CITY OF ALBUQUERQUE

PLANNING DEPARTMENT – Development Review Services

October 14, 2014

RE: **Green Jeans Farmery - 3600 Cutler Ave NE**
Conceptual Drainage Plan for Site Development for Building Permit
Engineer's Stamp Date (none) (File: H17D036A)

1 SITE PLAN
1" = 20'-0"

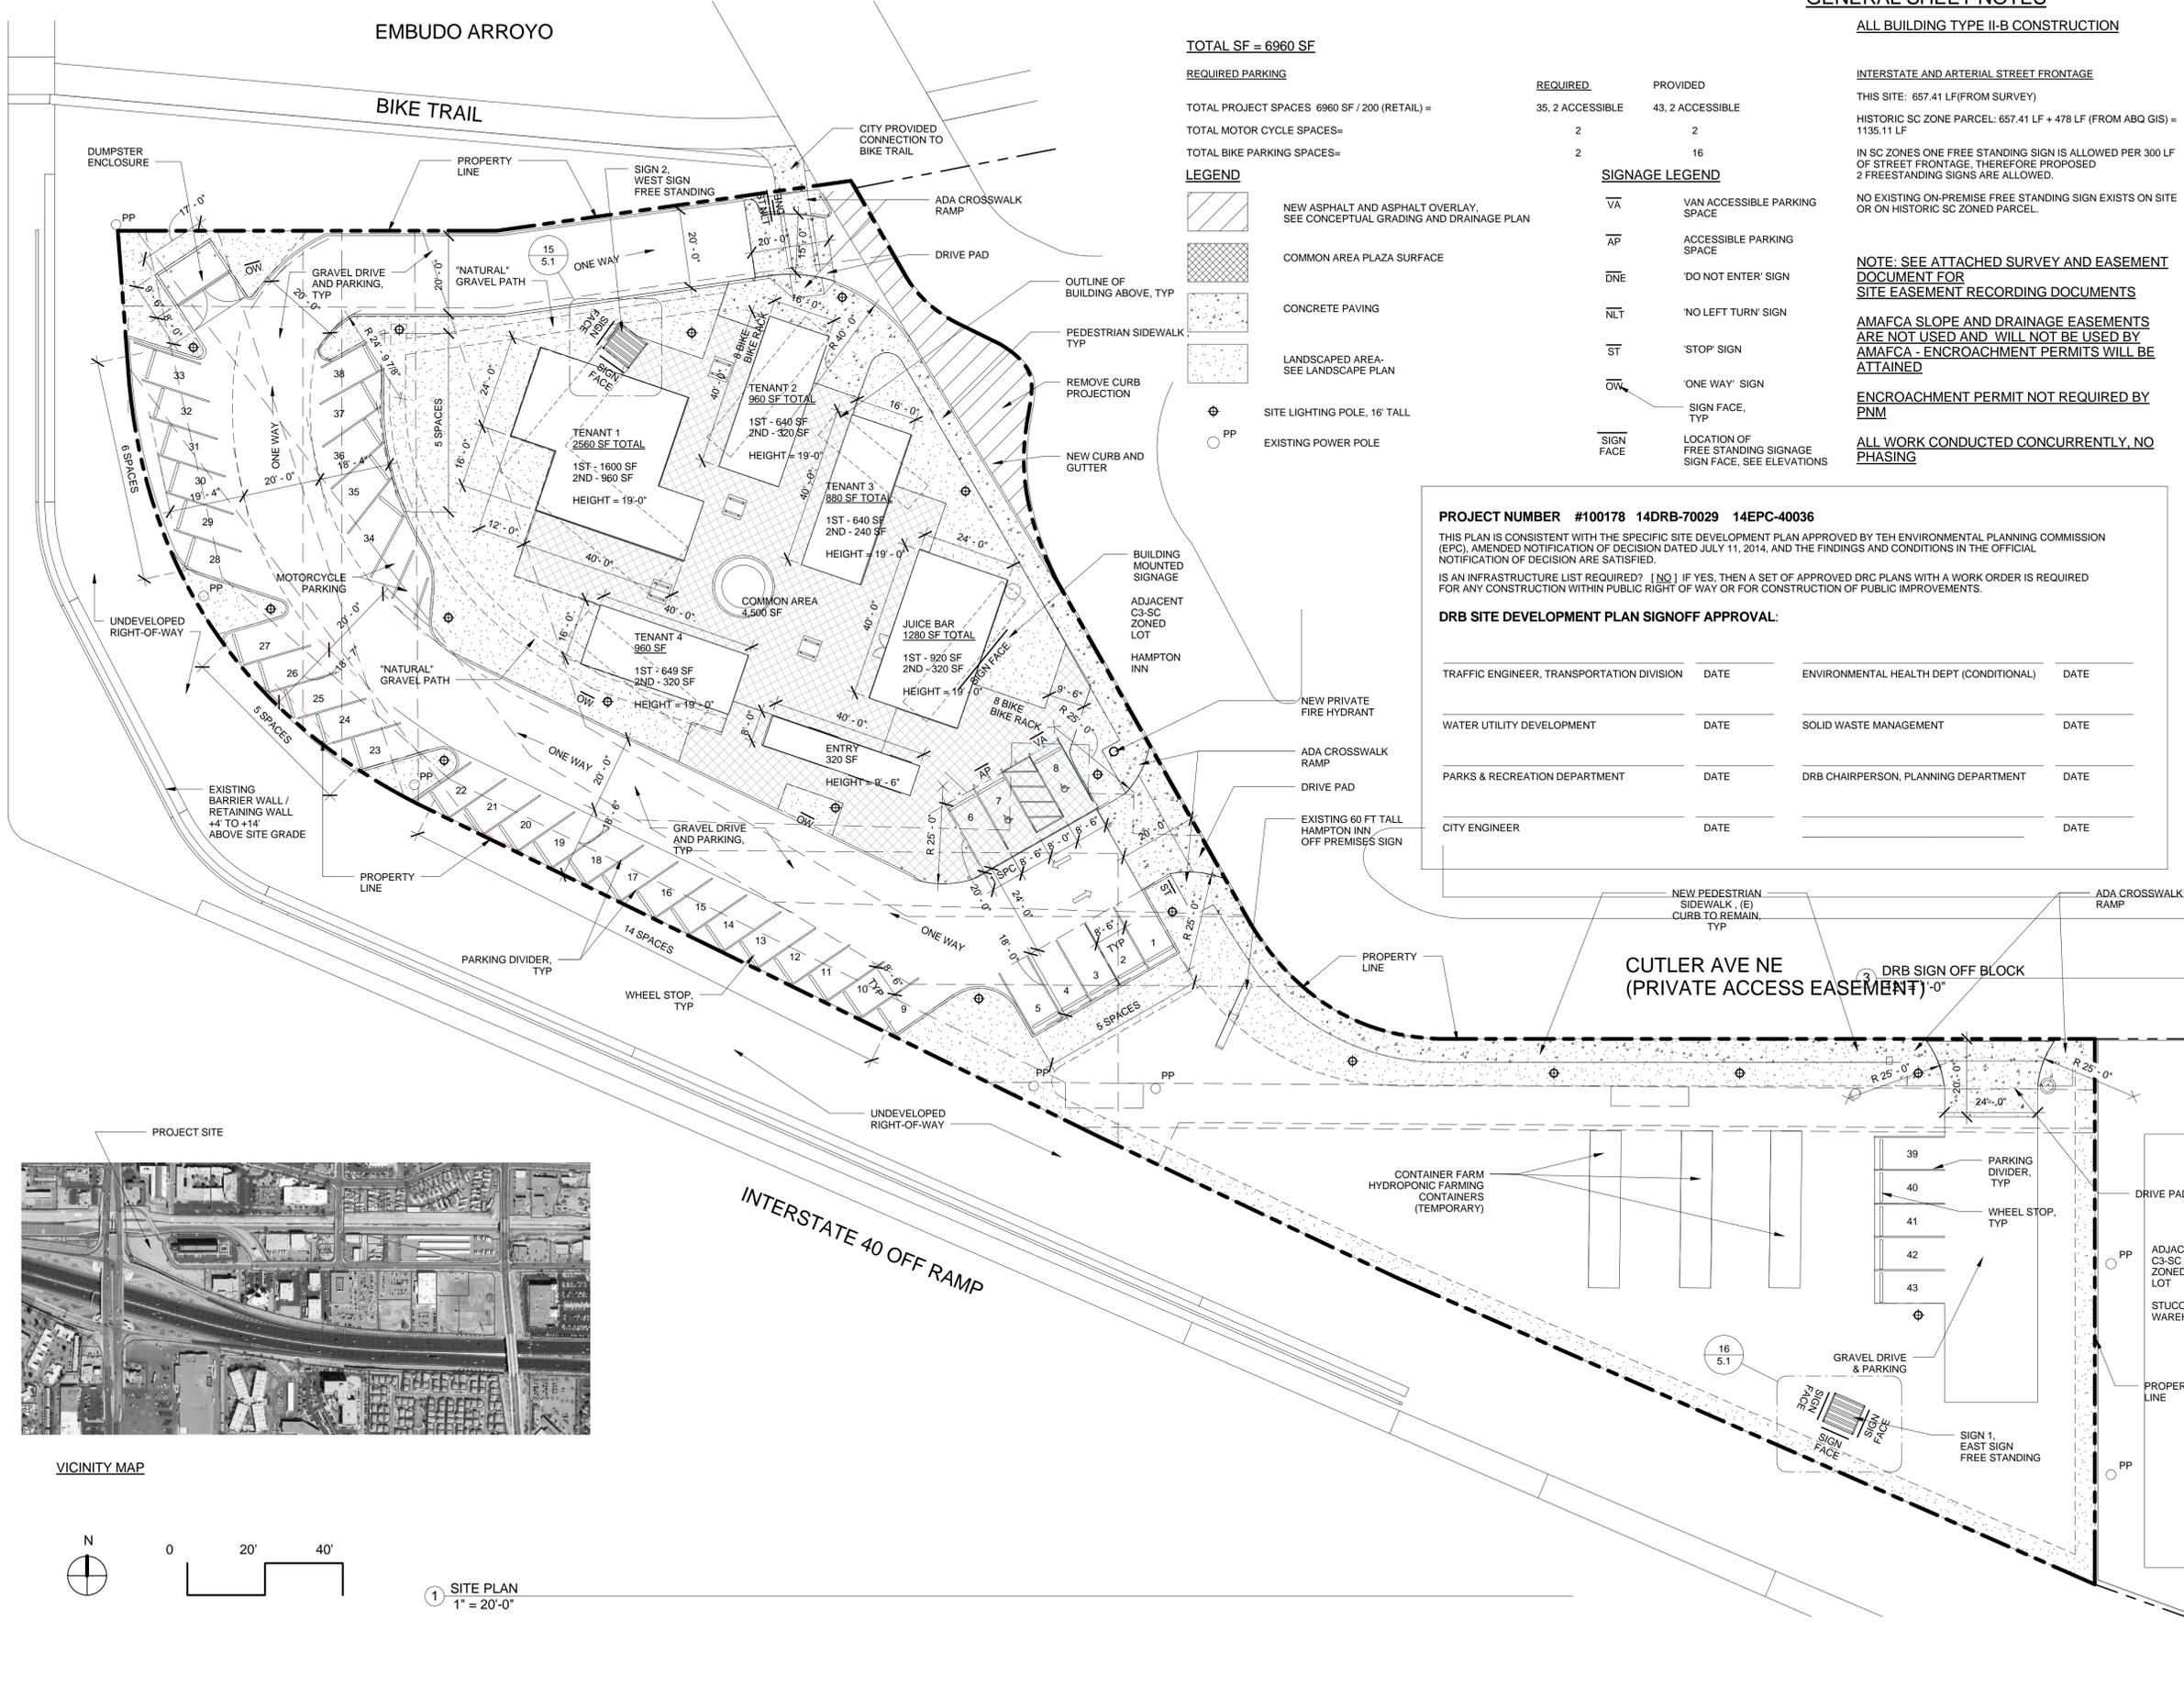
1. Approval from the NMDOT is a prerequisite for COA approval. We are waiting to hear from Tim Trujillo, as they may need access for maintenance.
2. An email from AMAFCA confirms that they accept the Site Plan with the condition that the buildings do not encroach into AMAFCA easements. Indicate on the Grading Plan AMAFCA easements.
3. The Site Plan does not show curb around the south and west property boundary (along the NMDOT ROW), but it is shown on the Grading Plan with curb cuts (keyed notes 6 and 7). To prevent erosion from concentrated flow, it is preferable to allow sheet flow into the NMDOT swale. Adjust flow arrows to reflect this.
4. Adjust Flow arrows to direct runoff from buildings and the commons area to the water harvesting/first flush ponds.
5. Show the private storm drain that goes through this site.
6. In the narrative, use "first flush" rather than "90th percentile..."
